From: Bloomer, David [mailto:David.Bloomer@lancashire.gov.uk]
Sent: 04 March 2014 14:22
To: Claire Booth
Cc: ENV LHS Customer Service
Subject: app3/2014/0124 The Crescent Dunsop Bridge.

Project: Proposed Extension at 5 The Crescent, Dunsop Bridge. For Mr and Mrs Hughes.		Ron Valovin, Architectural Services, 9 Green Drive, Clitheroe, Lancs. BB7 2BB. Tel. 01200 427167.	
Title: PROPOSED PLANS AND ELEVATIONS.			
Scale: 1 to 50	Date: 10/12/13	Drawn: JAV	File Name: 390-2

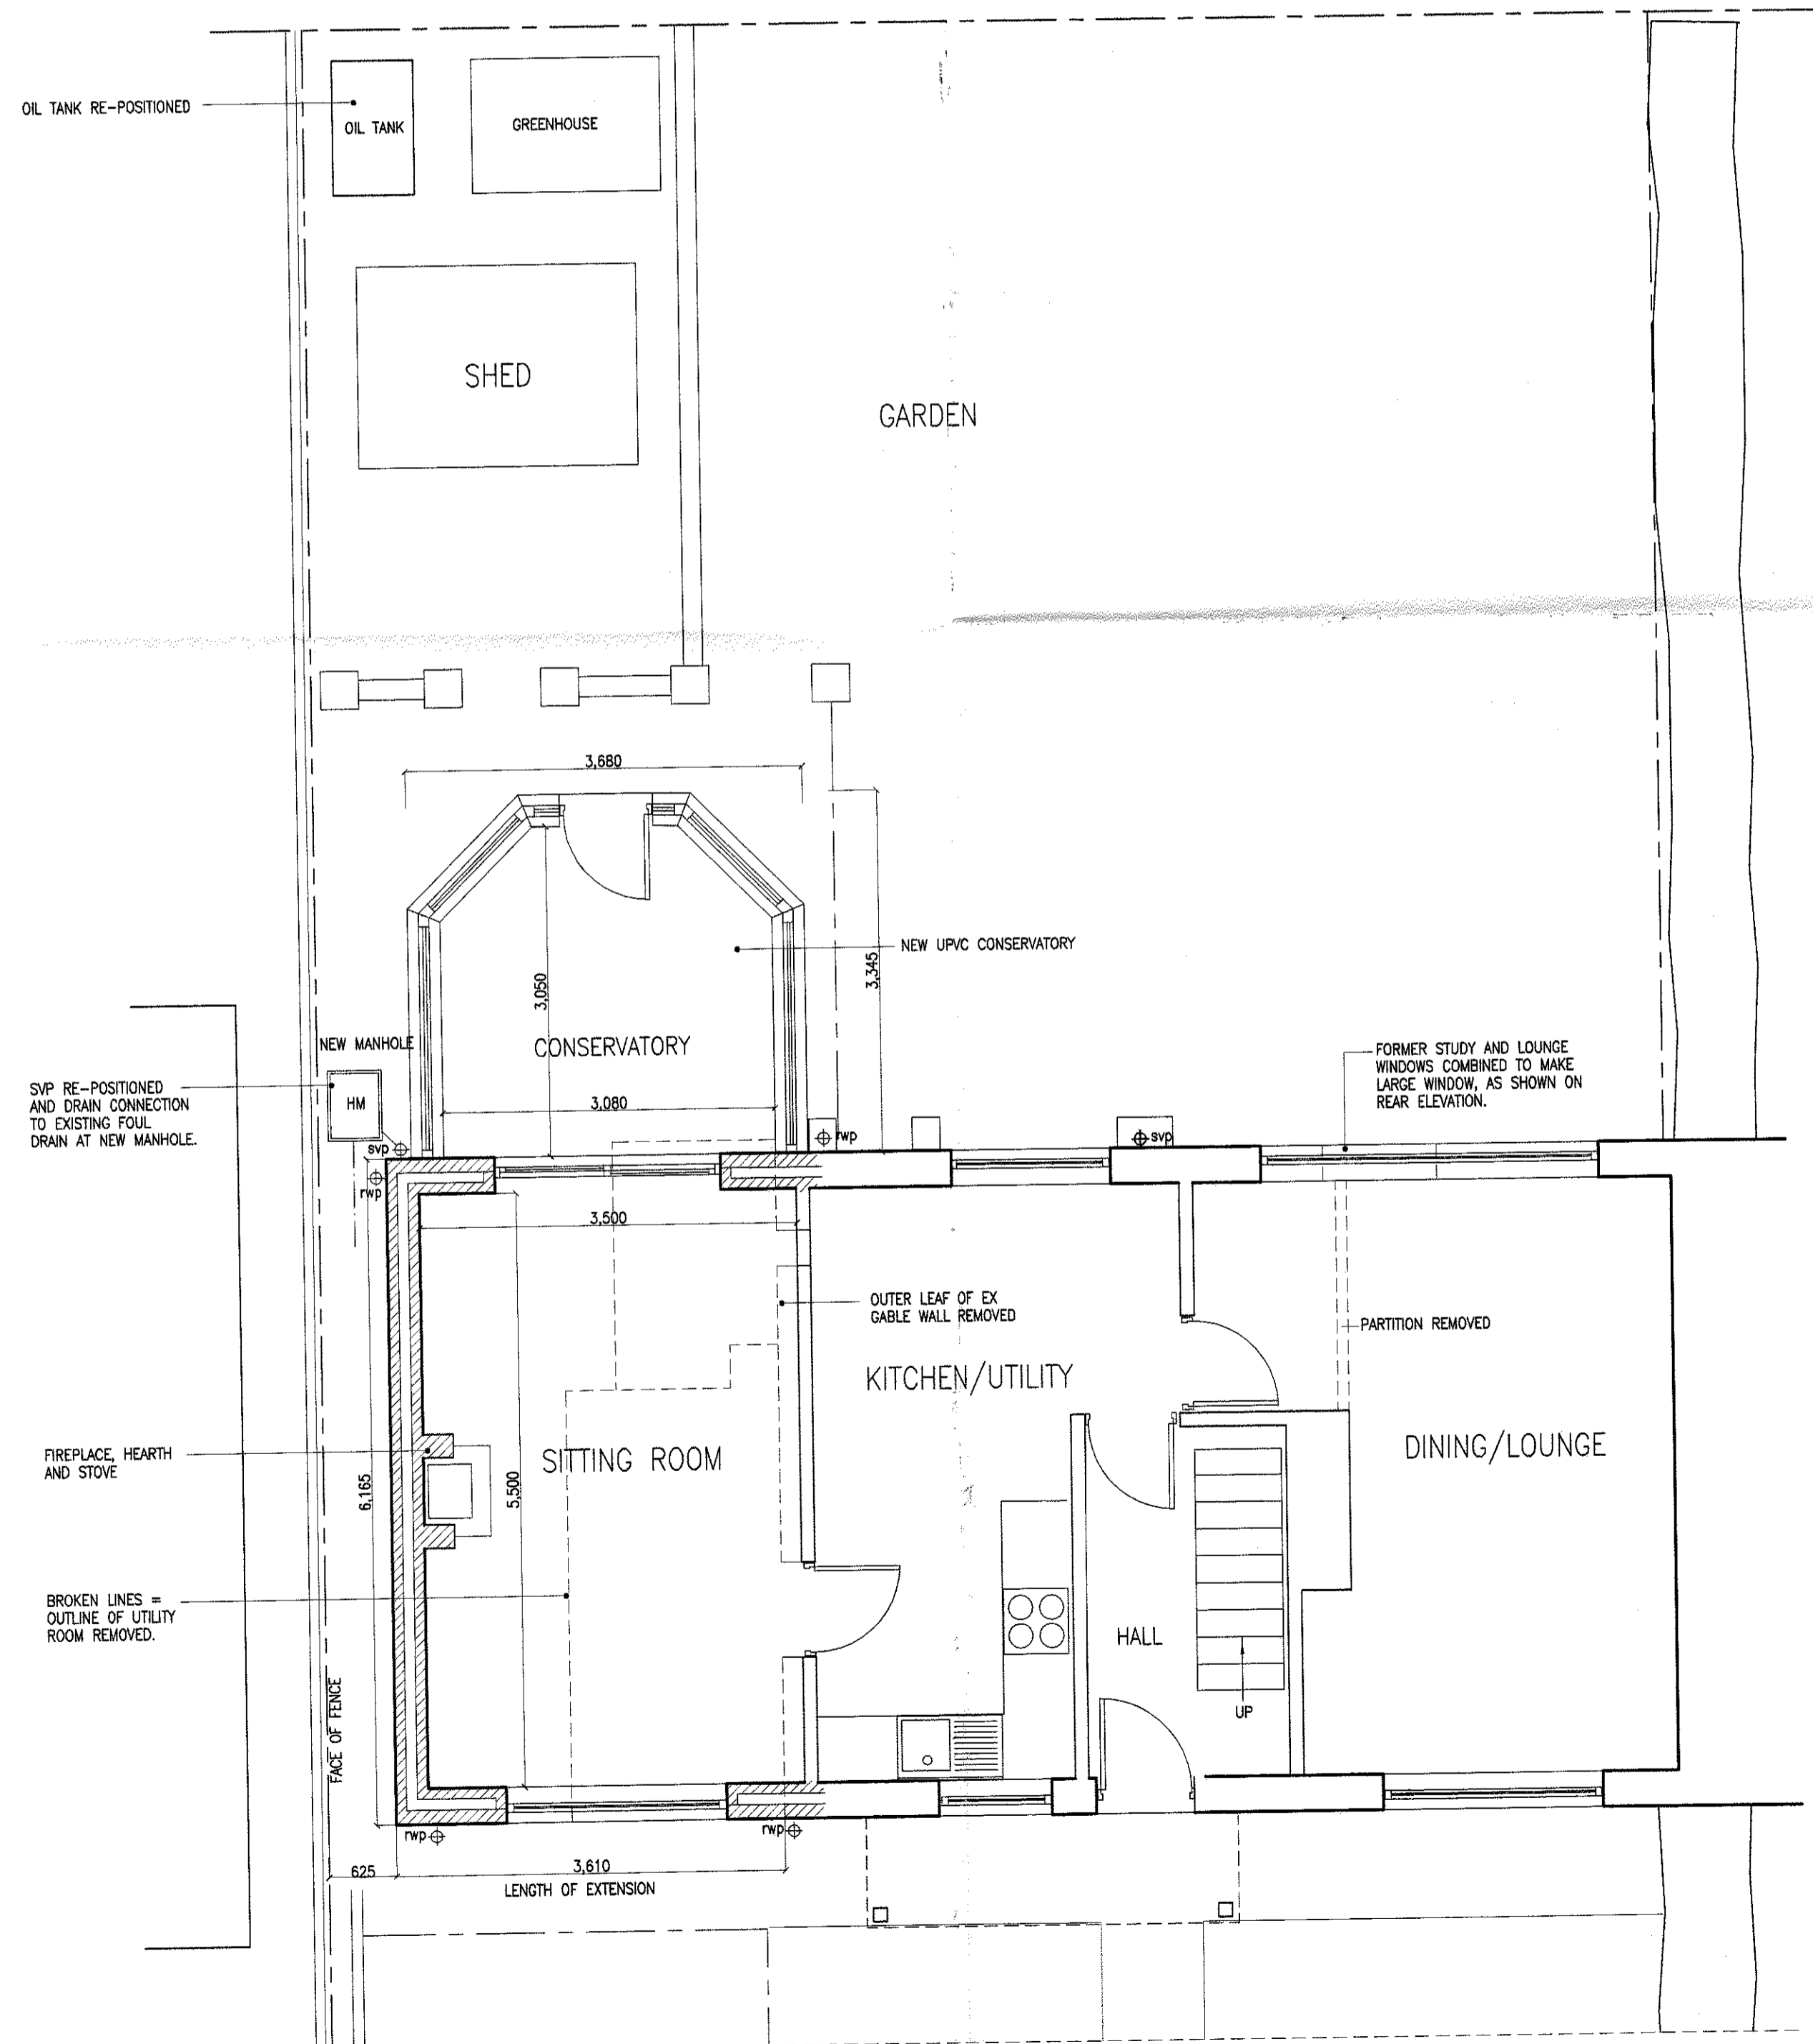
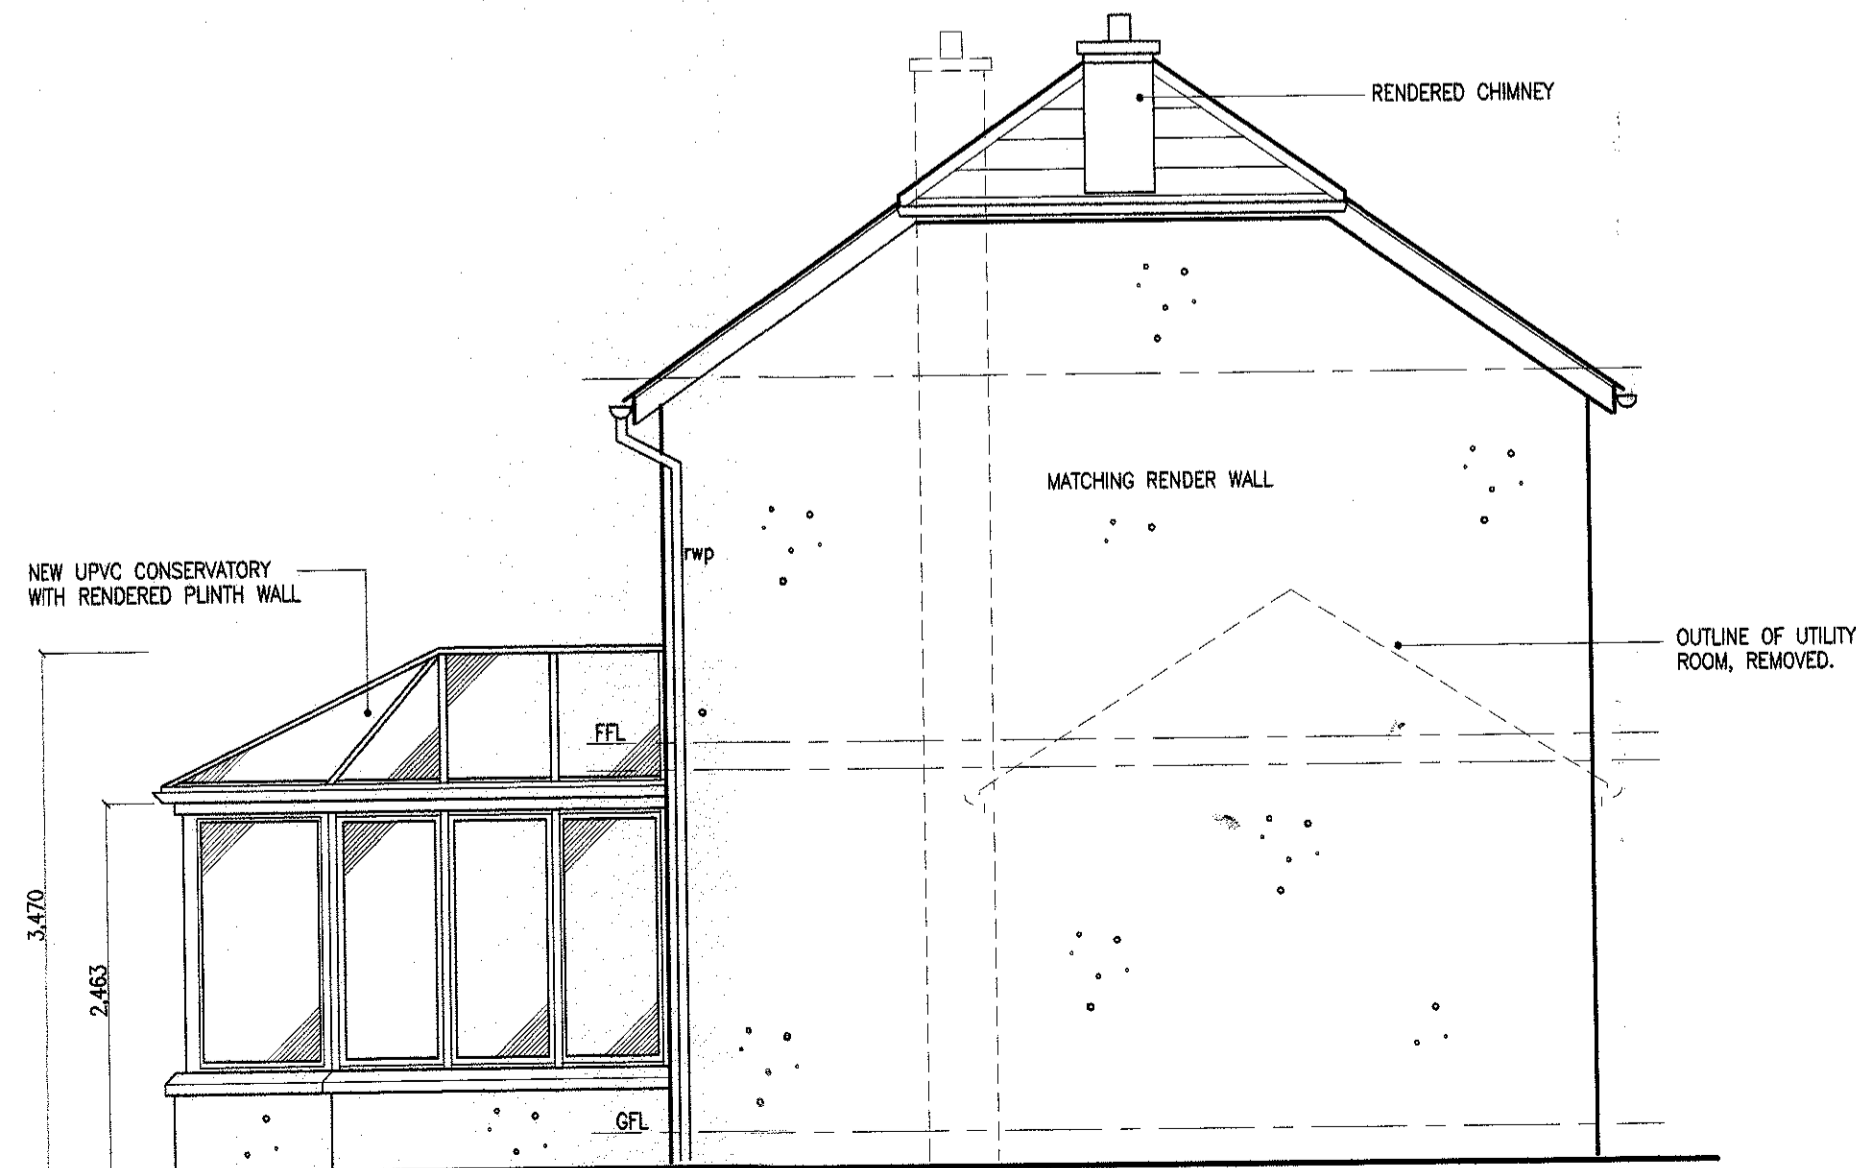
Whilst I would raise no objection to the principle of the development the site has the benefit of only 1 off street parking space. The proposal seeks to increase the number of bedrooms at the property from 3 to 4 I would expect a similar increase in the parking provision to at least 2 spaces. Therefore subject to the following condition being attached to any permission that may be granted I would raise no objection to the proposal on highway grounds

Prior to work commencing on site the applicant shall submit a plan, for approval by the planning authority , showing the provision of an additional parking space

The parking space shall be constructed in accordance with the approved plan prior to occupation of the proposed extension.
